**Application Number:** 2013-249                      **Application Date:** 11/05/2013  
**CBL:** 201 A005001                      **Application Type:** Plan Amendment - Staff Level III  
**Applicant:** Archetype /Hopkins William  
**Project Name:** Thompsons Point - Phase 1A  
**Address:** 1 THOMPSONS POINT  
**Project Description:** Modifications associated with the amended Site Plan Submission  
**Zoning:** B5/RPZ

**MEMORANDUM**

**Subject:** Application ID: 2013-249

**Comments Submitted by: Marge Schmuckal/Zoning on 12/10/2013**

PROJECT: BRICK NORTH BUILDING AT THE FOREFRONT AT THOMPSON'S POINT
SHEET TITLE: STAND ALONE BRICK NORTH SITE LAYOUT PLAN
CLIENT: FOREFRONT PARTNERS | LP

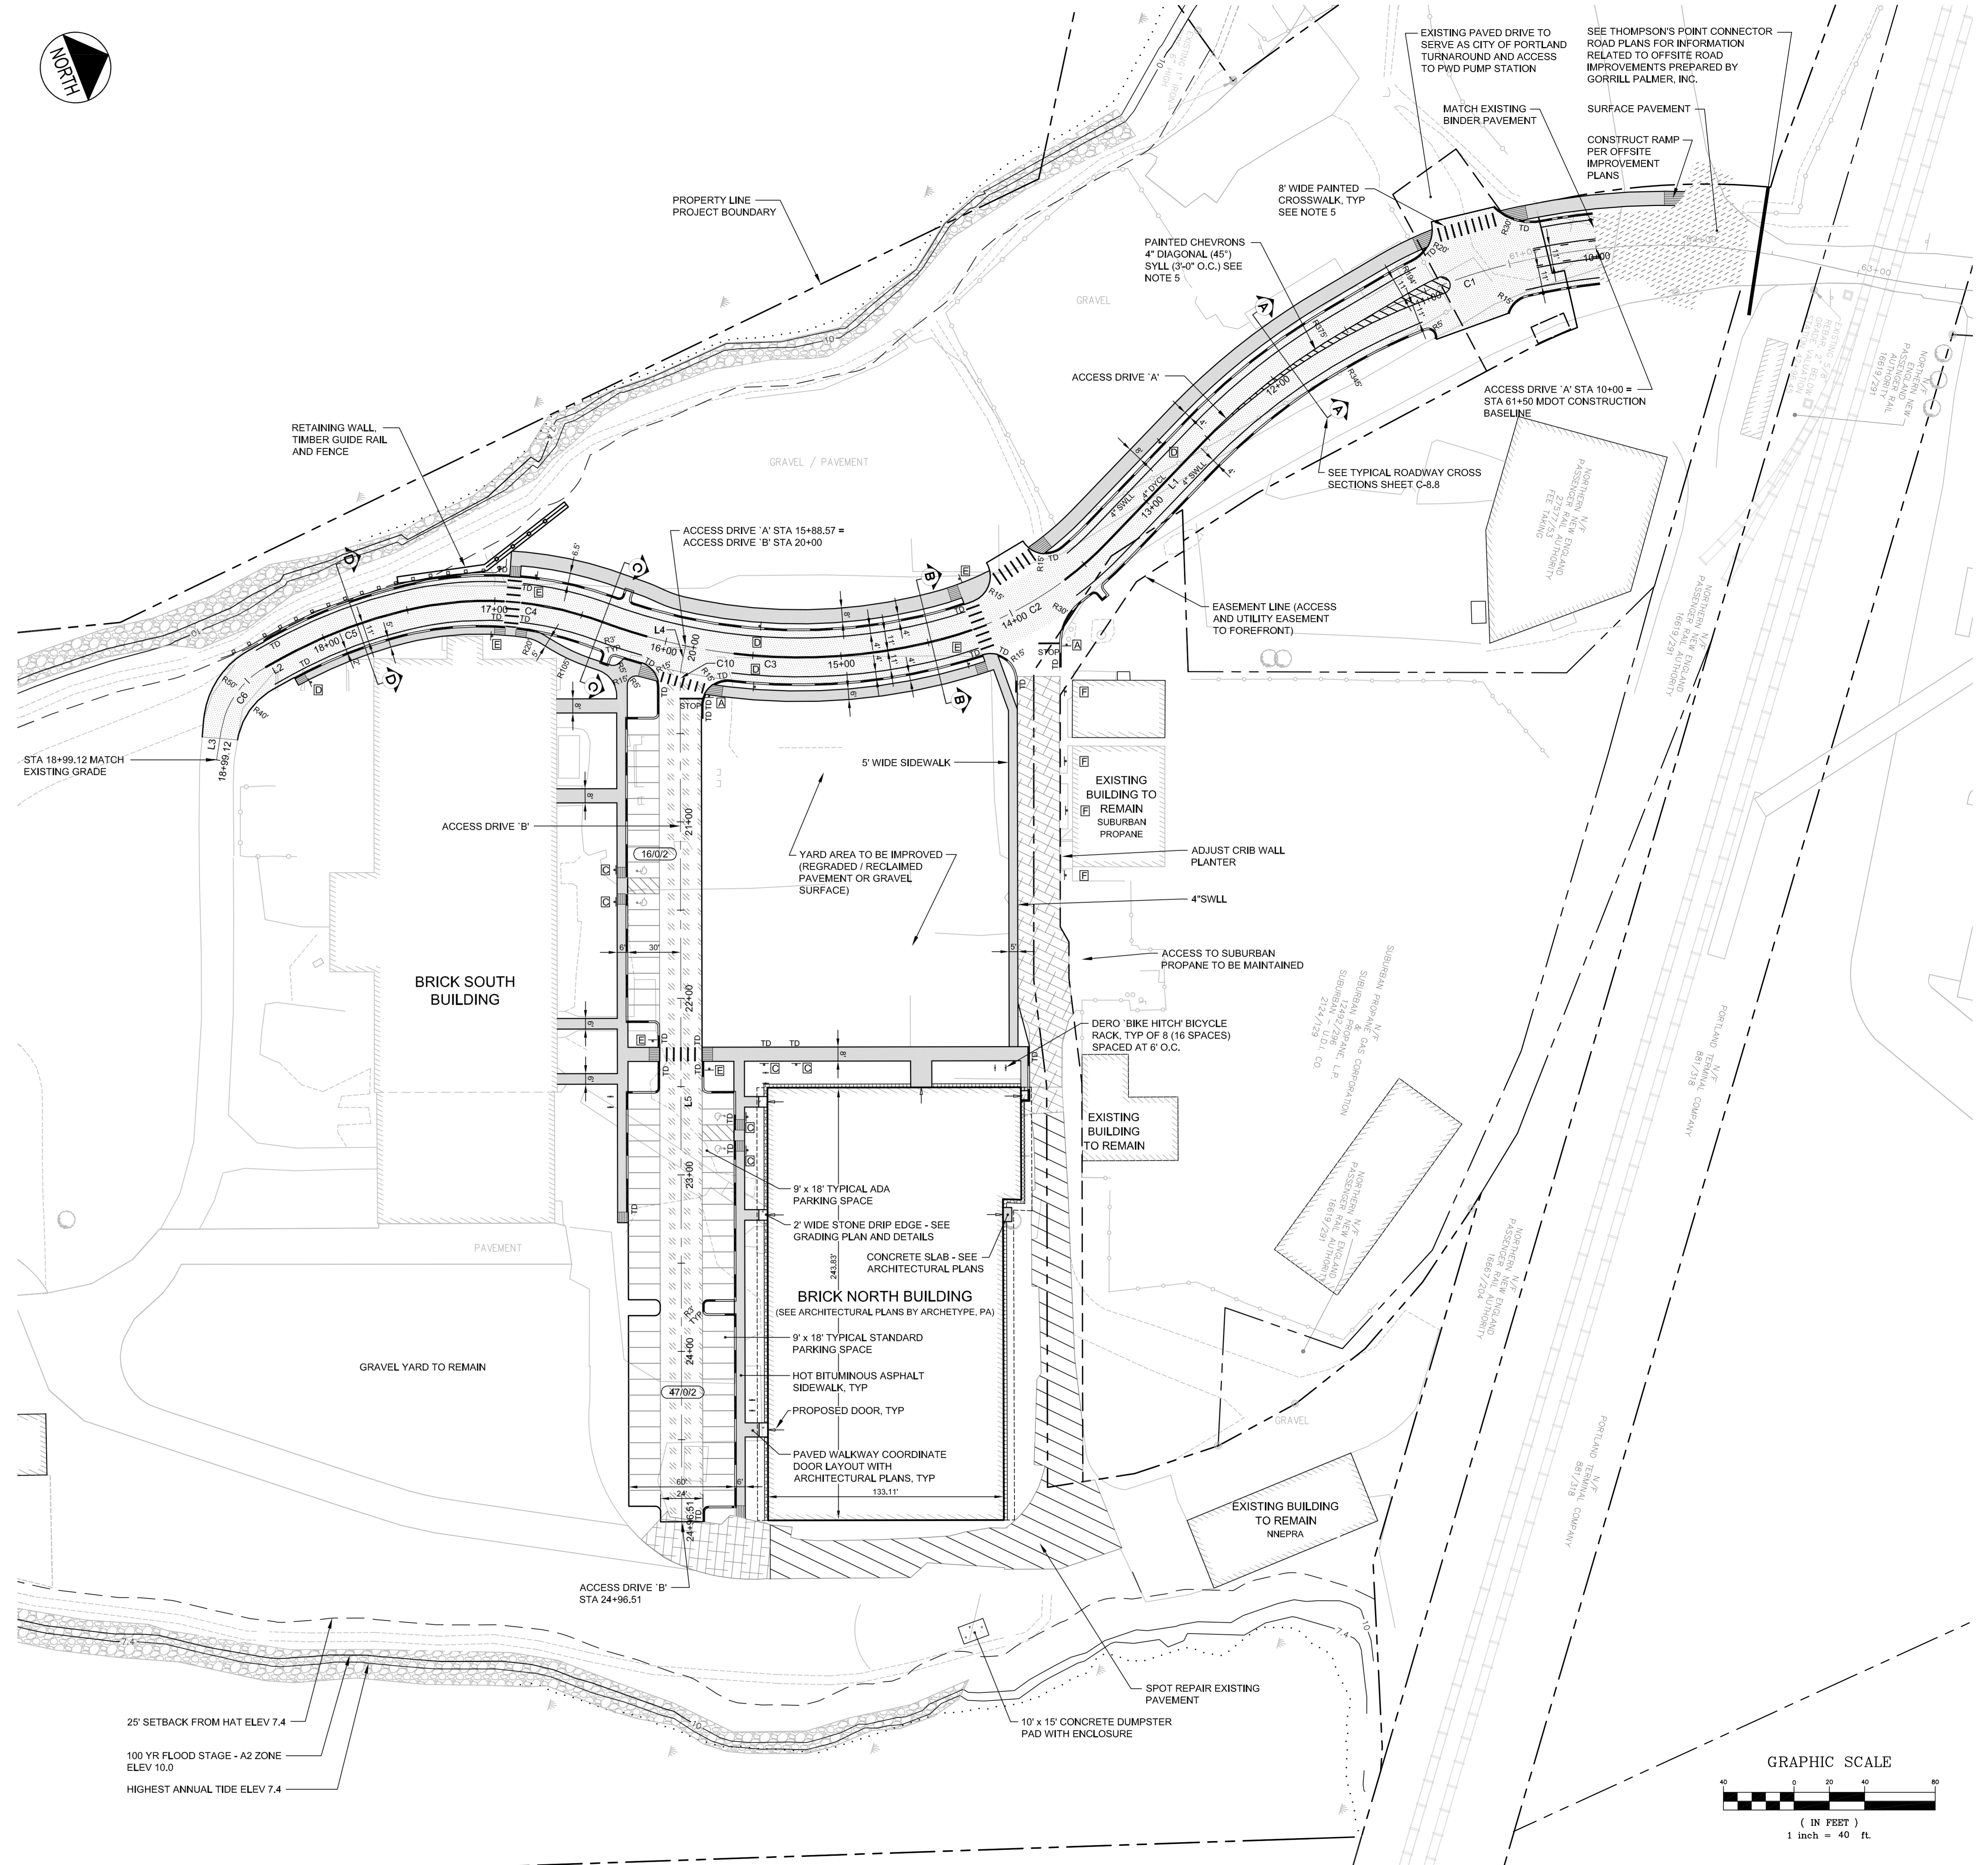
I have looked at the most recent submittals - revised 12/4/13 & uploaded to eplan on 12/9/13. The only thing that seems to have changed looking at the C-3.1 Site layout Plan is the parking area. The plan is now showing 61 parking spaces provided which matches the 61 shown as required. Other than that I don't see anything else having changed from Marge's comments submitted on 11/27/13. She mentioned submitting floor plans showing the uses and their floor area to back up the submitted information. We have not received floor plans yet.  
Ann Machado - Zoning Specialist

I have looked at the most recent proposal and the Site layout & utility plan. Based upon the provided information, it appears that this first building to be rehabbed as part of phase I will meet the parking demand. It would be helpful to back up the submitted information with floor plans showing the uses and their floor area. I am not sure that detailed information was submitted concerning the proposed phases and their time frames. It would help to review that information.
